**Our Case Number: ABP-309770-21**

**Re: Proposed development of up to 15 wind turbines with a tip height of up to 175 metres and laying of approximately 26km of underground electricity cabling to facilitate the connection to the national grid, and all associated site development works  
Townlands of Camagh, Carlanstown, Coole, Clonrobert, Clonsura, Doon, Monktown, Mullagh, Newcastle and other townlands, Co. Westmeath**

We, John and Clarissa Delamere, wish to make an observation on the Further Information supplied in relation to Case reference: PA25M.309770: Townlands of Camagh, Carlanstown, Coole, Clonrobert, Clonsura, Doon, Monktown, Mullagh, Newcastle and other townlands, Co. Westmeath.

Figure 13-21: Unnamed bridge on  $\mathcal{L}^{nd}$  edition 25 inch OS map in relation to proposed access road to T15.

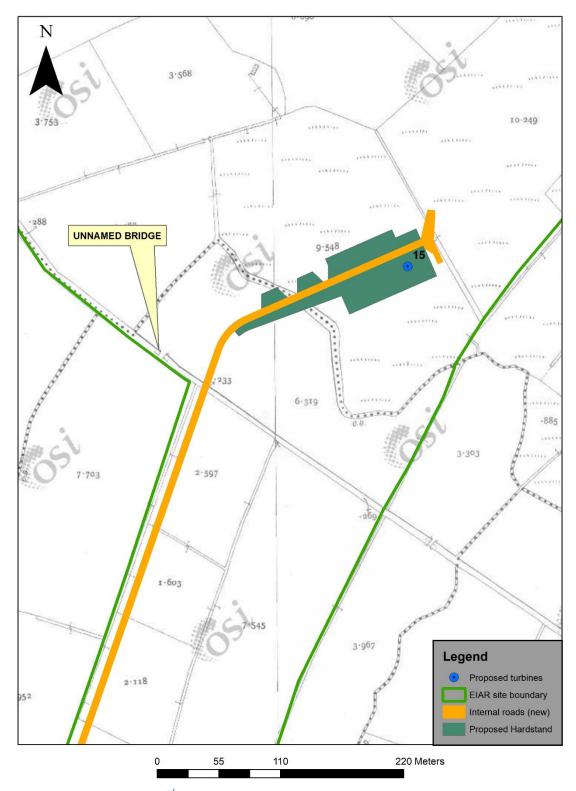
T1 and T15 are picture in the location diagrams as being on two water courses. T5 is so close that it is impossible to say where the foundations will be. The access to T15 is over a stream, according to the report there will be a flat new bridge over the stream – this will be replacing a 19<sup>th</sup> Century stone bridge, surely this is not allowed.

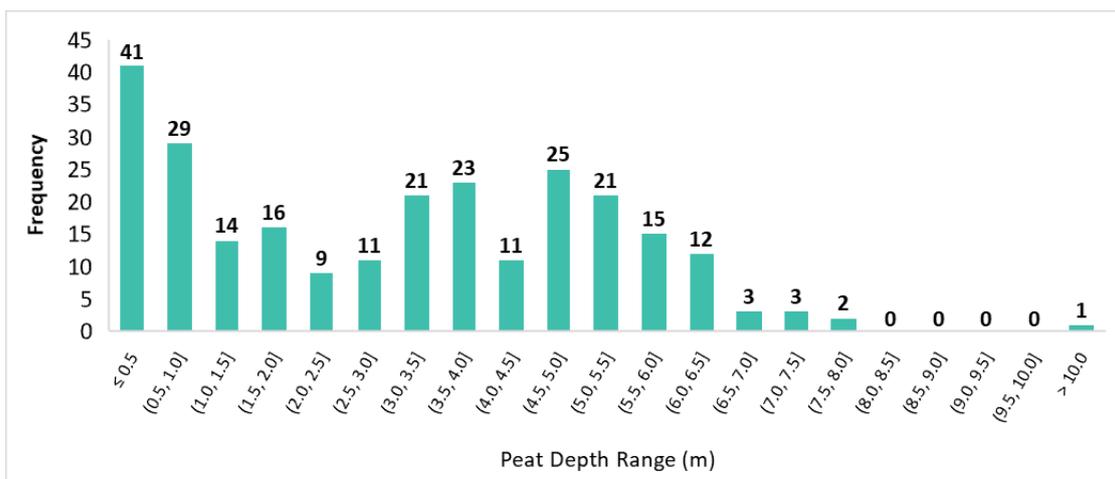
2.4.1 How can you get such different peat depth readings just by changing the surveying method? If there is a large difference for T12 could there be large differences for all the other turbines? Is the soft

clay under the peat likely to make an unstable footing or will this mean a substantial increase in the amount of concrete needed in construction?
